Brighton Ave Hampton Inn

The Hampton Inn on Brighton Ave is under construction and they have decided to build with a panel system. Because of this we have run into a few areas that need revised details. One is in the attached sketch which shows how a non-bearing partition is attaching to the 1 hr corridor wall. I have sketched what we drew in our set and I have sketched what they would like to build based on how the panels are constructed. The owner wants to make sure that the detail still meets code. I wrote to:

Ok, thanks, I have reviewed the information you provided as an alternative design at the intersection of a partition at a rated wall membrane. The proposal is to interrupt the gypsum membrane rather than keep the continuity, by butting the partition to the rated wall using the char rate of the wood studs to maintain the fire resistance.

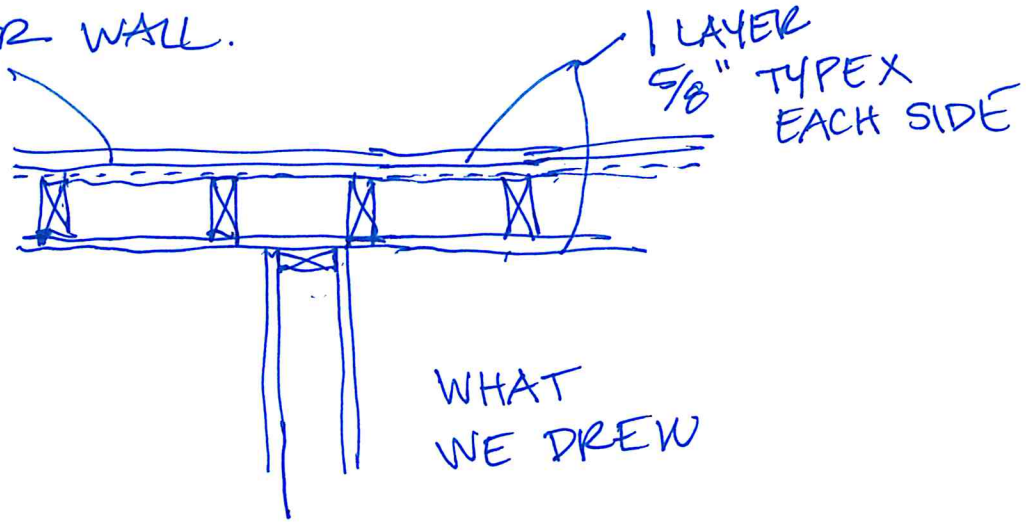
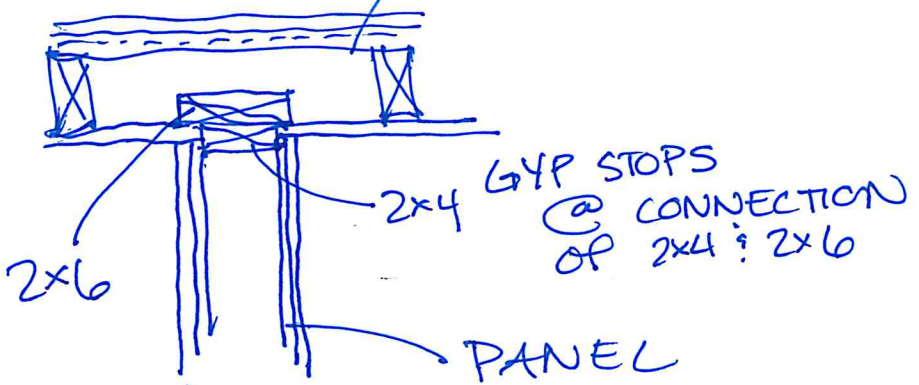
I've seen this type of a detail used many times for your condition. 1.5" of thickness of blocking is good for 1 hour of fire resistance, the IBC points to the NDS for fire resistance, and chapter 16 covers it. Note that this is for non-structural blocking, which I believe you are specifying for the field change, structural members are analyzed slightly more conservative. The reason for the clarification on the ceiling penetration was that officials were more concerned with fire rising up and spreading, it shouldn't have been necessary but was added for that reason. A wall to wall application is usually not questioned, to our knowledge.

Can you please specify what the finished layers are on the panel wall are?

The corridor wall is rated so that is a layer of 5/8" type x on each side. The partition meeting the corridor is an interior non-rated partition so that would have 5/8" gyp. The type X on the corridor would butt up against the stud connection.

This code path is acceptable as stated in Sec. 721.1 for the calculated fire resistance of exposed wood members per Ch. 16 of NDS. The sketch you provided at this intersection should be further enhanced as shown in the attached tested wall assembly UL U305 as this further validates the charring method design option.

At this point we're still going back and forth with the owner and wood panel company, who say that they used the attached detail many times across New England. The 2x6 + the 2x4 have 3 " of thickness which should rate about 2 hour by charring calculation in what is a 1 hour wall. The difference between the attached detail and UL U305 is 1-1/2" extension beyond the 2x4 as opposed to 1" extension in the attached detail. Not being an engineer I went to Marc Rivard PE of woodworks , an organization that provided expertise and consultation on wood fire resistant assemblies. He stated the attached was fine for the intersection of an unrated wall with a fire partition.

Please revise this sketch and I will file it with the approved permit documents for this project.

Ok, this design is acceptable, the flanking 2x's may just be a typical detail for an intersecting partition to provide nailing. I will file this with the permit.
